Planning and Development Services
Arun District Council
Arun Civic Centre
Maltravers Road
Littlehampton
West Sussex
BN17 5LF

Developer Services
Southern Water
Sparrowgrove House
Sparrowgrove
Otterbourne
Hampshire
SO21 2SW

PLAN-017056

Proposal: Application for approval of matters reserved by conditions imposed under BR/54/16/PL relating to Conditions(s) 10 - Surface water drainage scheme, 16 - Measures to divert public sewers, 17 - Foul & surface water sewerage disposal details & 27 - Details of exact location of the rising main & foul sewer pipe identified & plan identifying Southern Water Infrastructure of locations of the pipe run.
University of Chichester, Upper Bognor Road, Bognor Regis, PO21 1HR.
BR/342/16/DOC

| TITLE:   | SOUTHERN WATER<br>S185 DEVELOPER DIVERSION APPLICATION PLAN<br>LONG-SECTION<br>PIPE BED & SURROUND DETAILS |

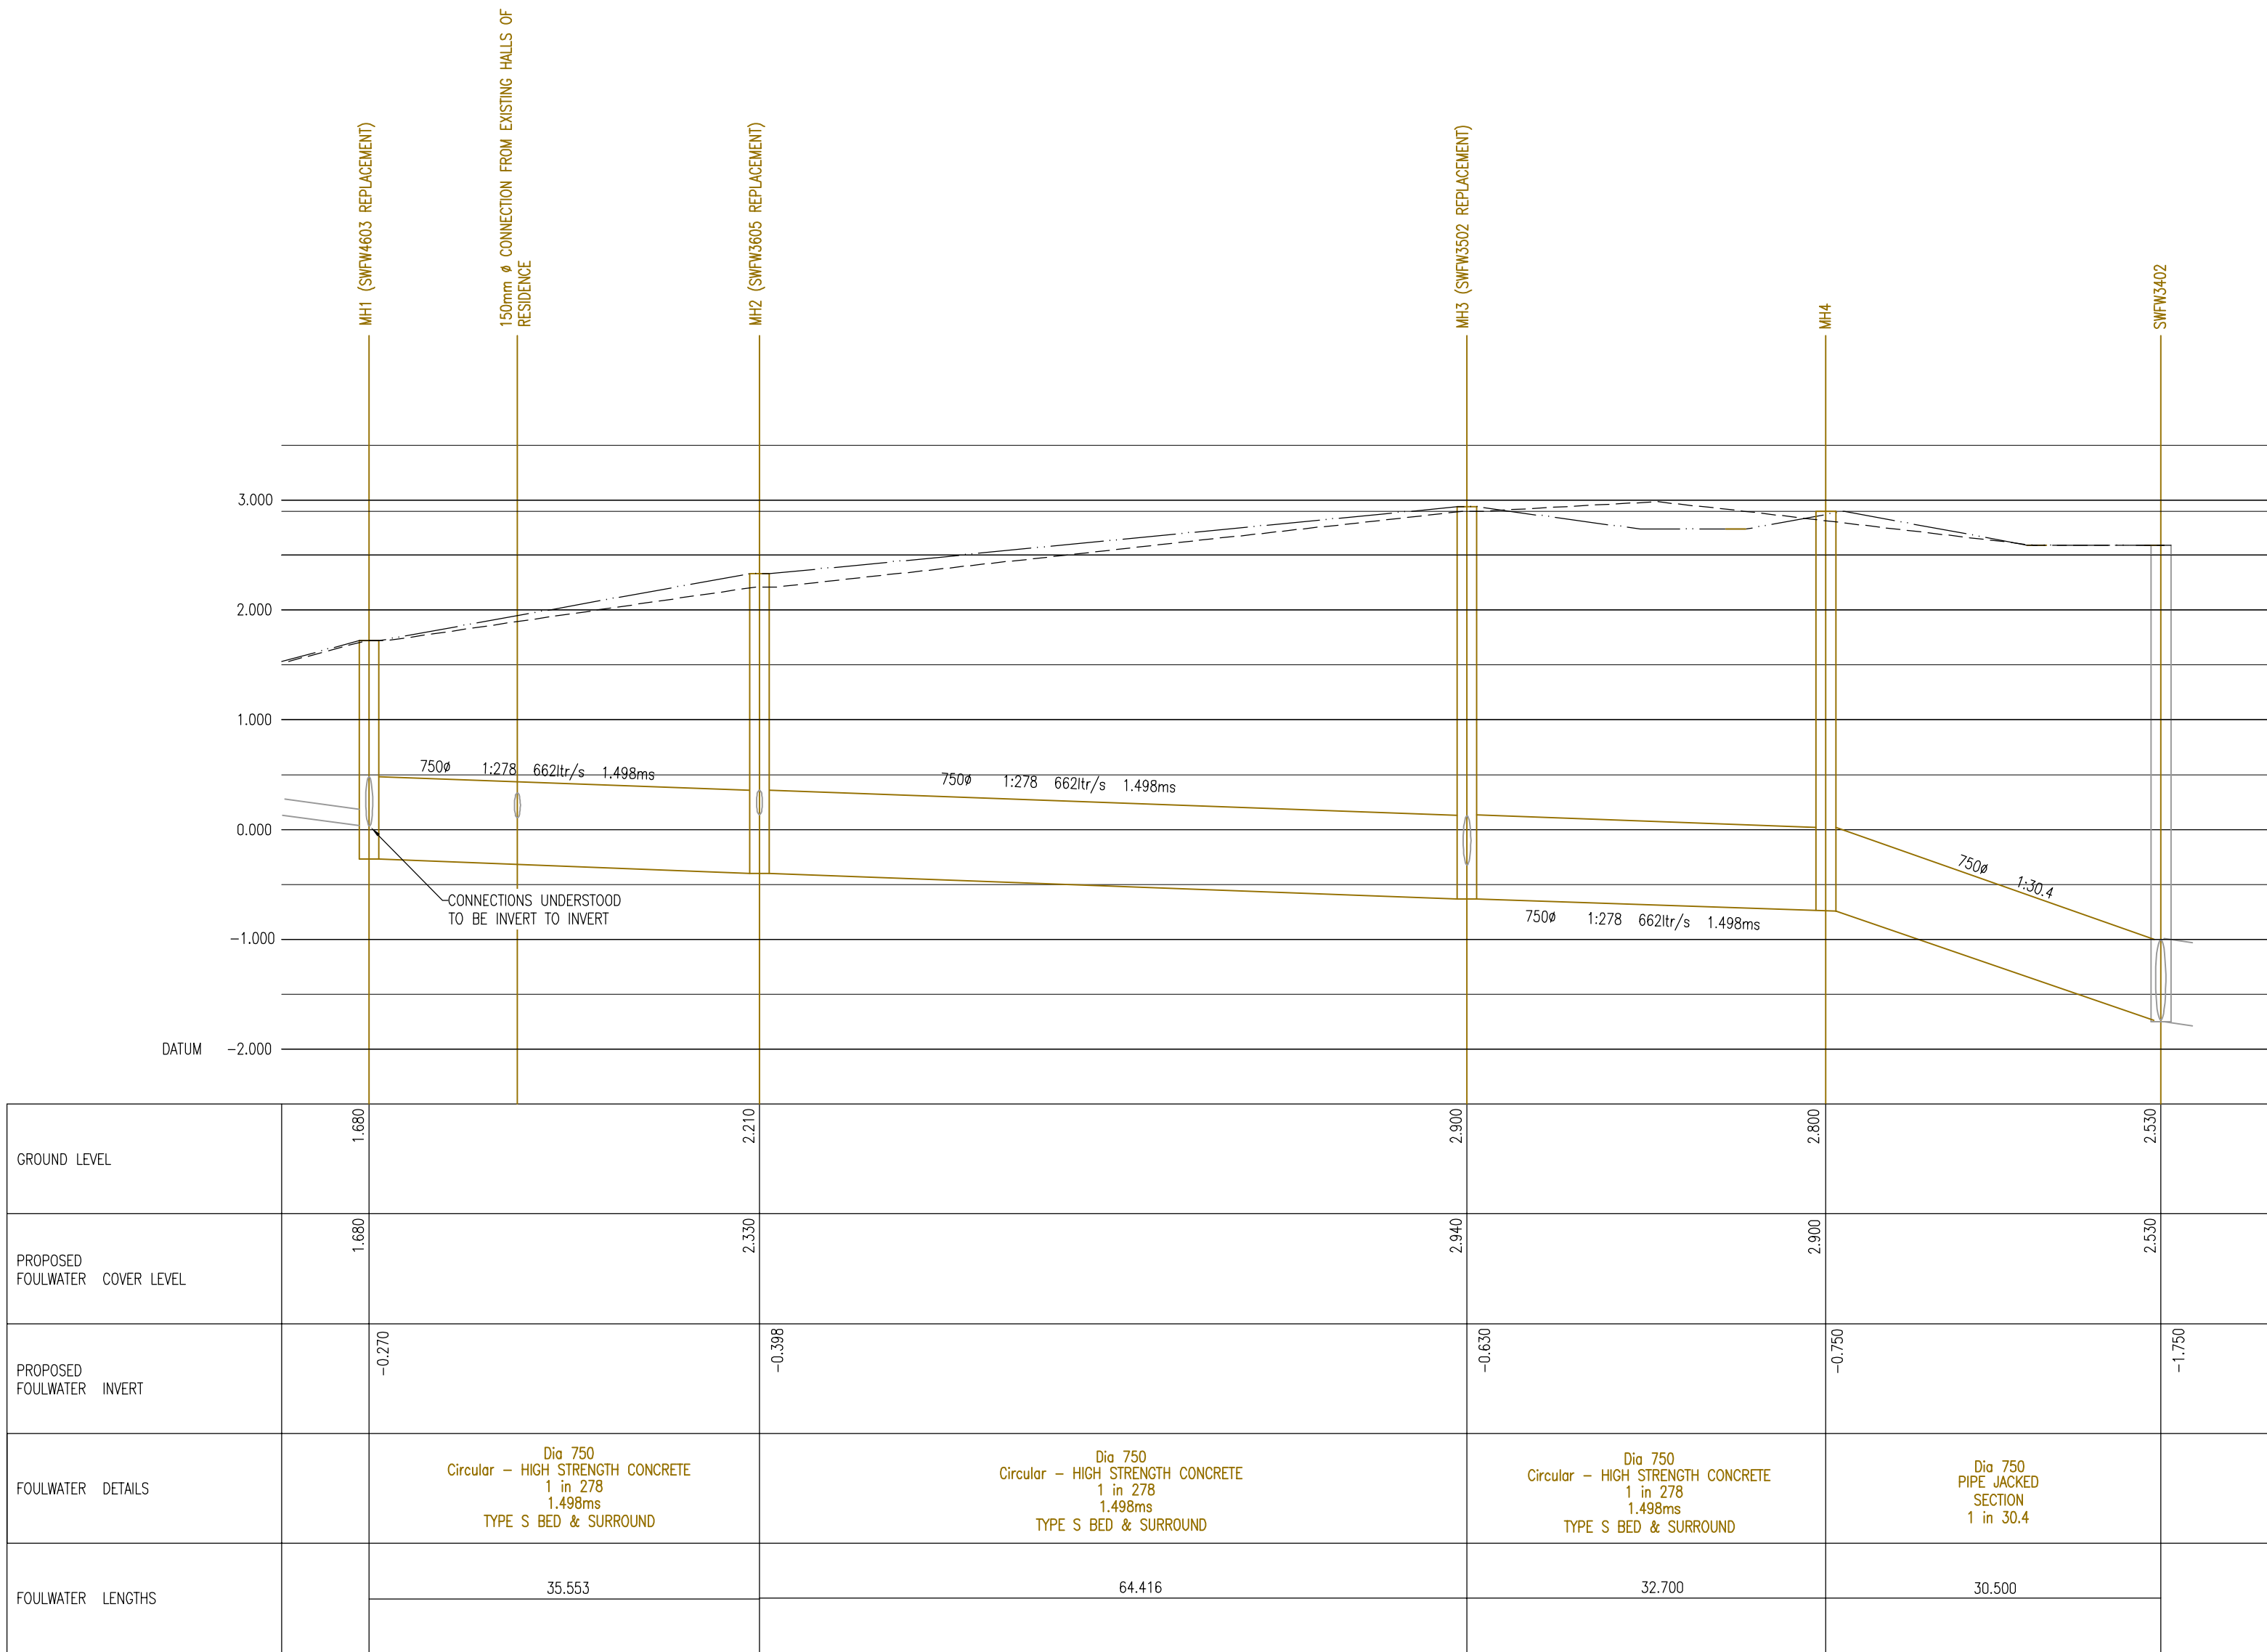
Southern Water would recommend discharge of condition 16 relating to public foul sewer diversion. The diversion works should be carried out in accordance with approved details (dealt under our ref SWS.S185.001763. The applicant will be required however to provide details of protection measures for the located 600mm foul rising main.
